File: SF17/42025
Job ID: DOC17/449172
Your Ref: SSD 6611 MOD 1

Heritage Council comments on Renewal of Marine Structures Cockle Bay, Darling Harbour – s.96 modification of project approval to include an additional 24m long floating walkway (SSD 6611 MOD1)

Figure 5: The proposed (re-included) ANMM Walkway section circled

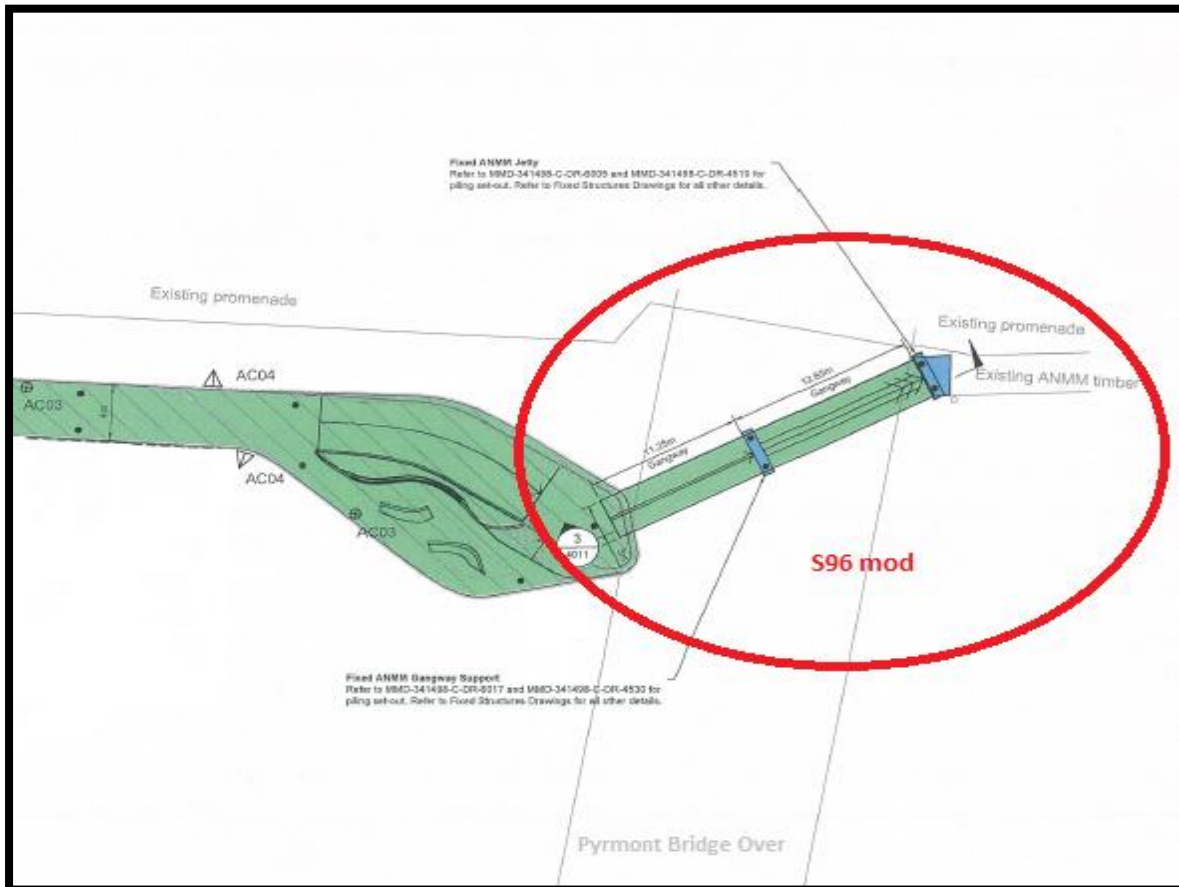
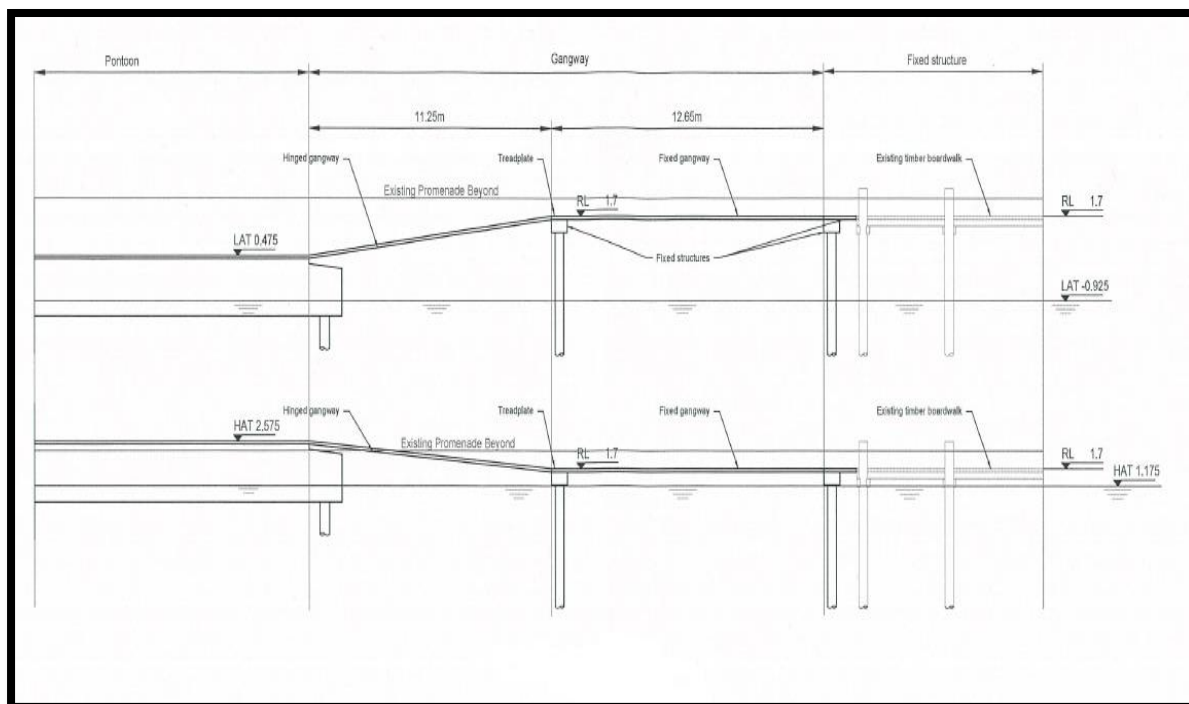
Following a review of the Maritime Archaeological Survey and Statement of Heritage Impact (MAS&SOHI) undertaken by Cosmos Archaeology 2015, it is apparent that the impact on heritage of the floating walkway extension underneath Pyrmont Bridge has not been adequately assessed as no archaeological investigation has taken place in this area (MAS&SOHI: p34). It is known both from historical information (MAS&SOHI: Annexe A p6) that there may be archaeological sites or relics in this area; in particular, the original 1857 Pyrmont Bridge.

No mention of piling was included in the original proposal in regards to the floating structure under Pyrmont Bridge. The MAS&SOHI specifically states that the structure "will float on water" (p80), and does not mention that piles are planned for this area and it is not clear in concept images for the site where it extends under Pyrmont Bridge (MAS&SOHI: p72).

The documents have been reviewed and it is considered that there has been insufficient archaeological investigation to assess the heritage impact of the proposed re-inclusion of the 24m section of walkway on the area of the floating walkway under Pyrmont Bridge.

An underwater inspection of the area under the proposed floating walkway beneath Pyrmont Bridge be is to be undertaken by a suitably qualified and experienced maritime archaeologist to:

- assess the presence (or likely presence) of archaeological sites and relics in this area, both above and below the seabed, and
- submit a Heritage Impact Statement which includes the findings of the inspection and an assessment of the heritage impact and mitigation measures in relation to the installation of the proposed piles associated with the proposed floating walkway under Pyrmont Bridge.

The Heritage Impact Statement must be submitted to the Heritage Council of NSW for comment and approved by the Department of Planning and Environment.
